BUILDING CODE OF AUSTRALIA ASSESSMENT REPORT

Project: Block 1&4N
20-102 Broadway, Sydney

Client: Frasers Broadway
Report: RE142467 Issue 1 draft
Date: 19 June 2014

01 Cladding Type D - Typical Bedroom Slot Facade - Section
1:20

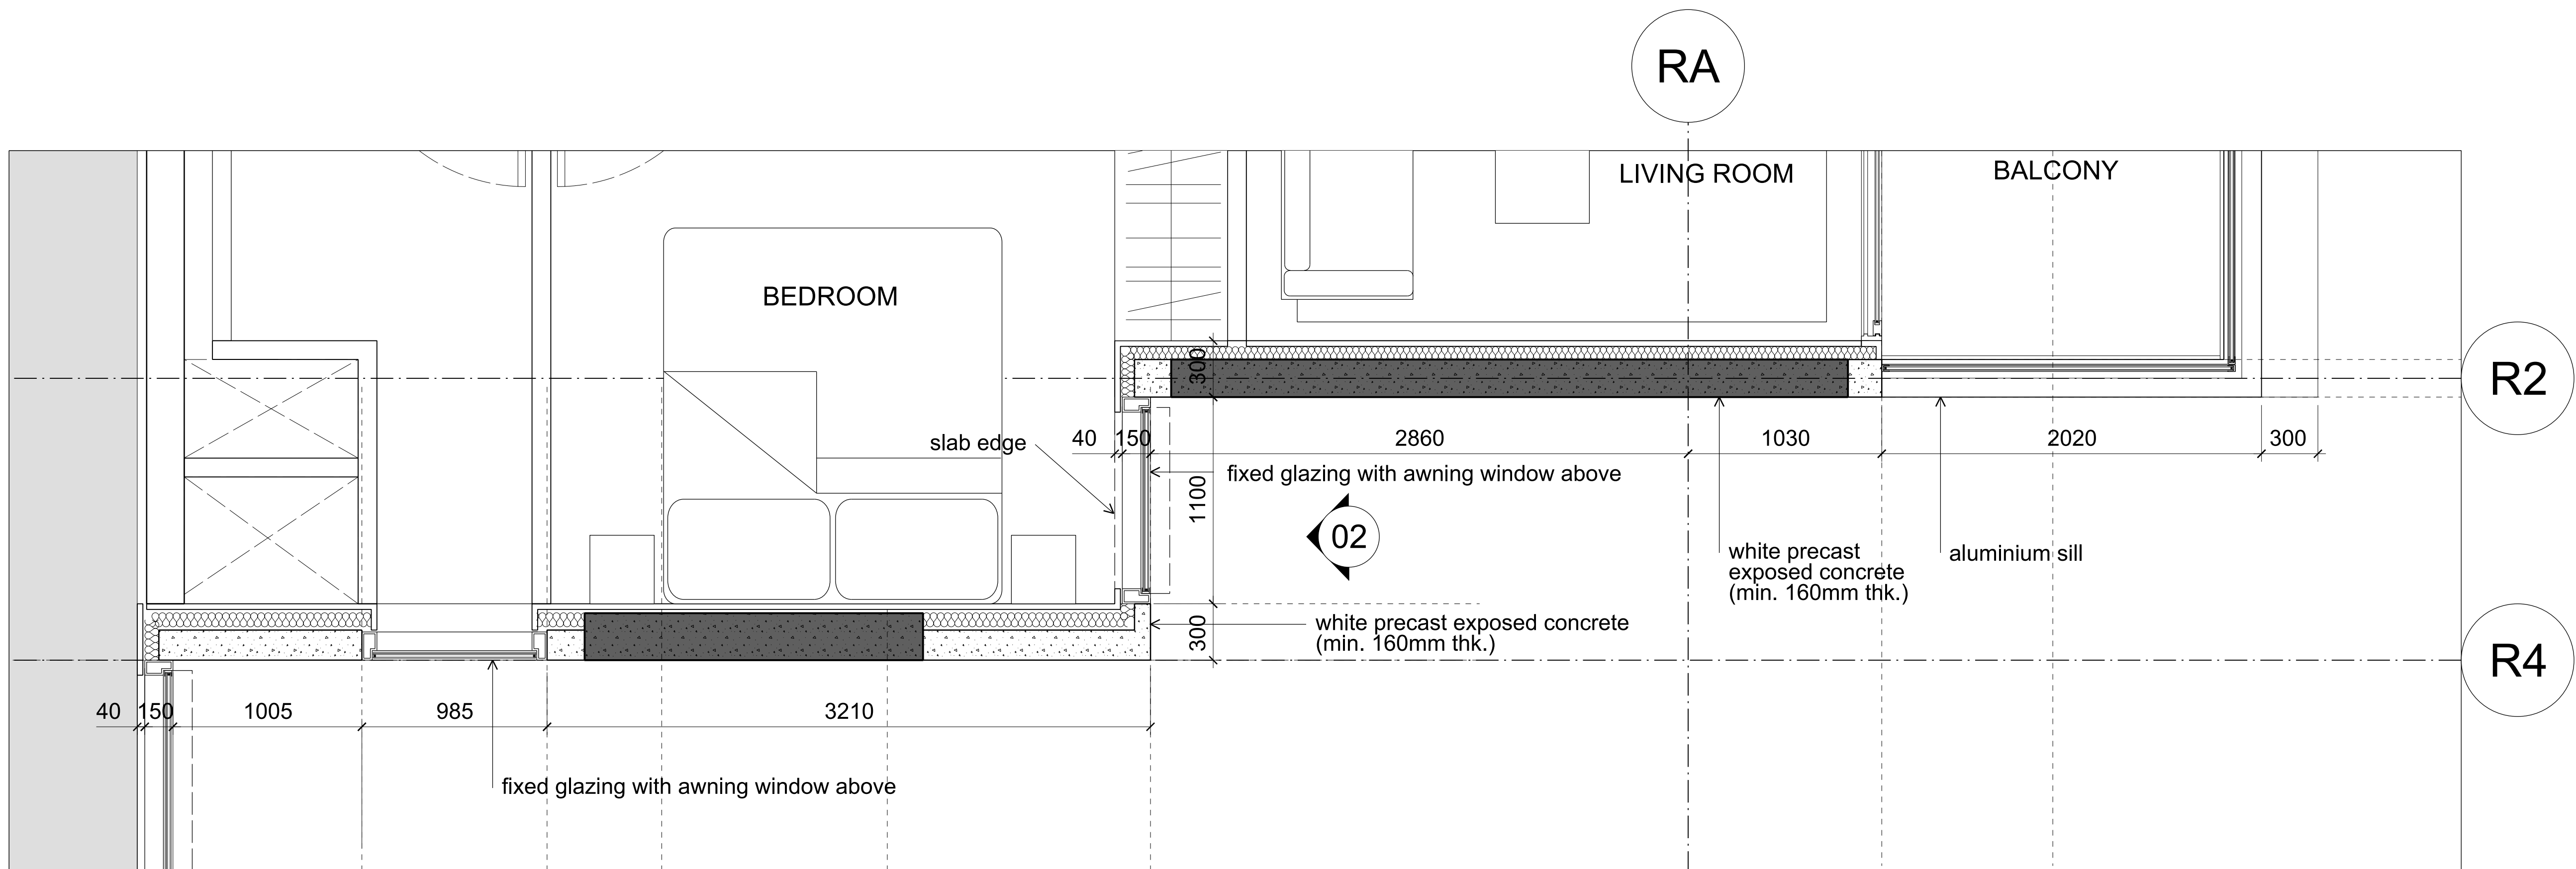
E2.2 Zone smoke control	The loading dock and retail tenancies are not proposed to contain zone smoke control.
F4.1 Natural light	The study rooms on Level 04 to 17 bounding the west slot rely on natural light via the slop which does not comply with F4.2(b).
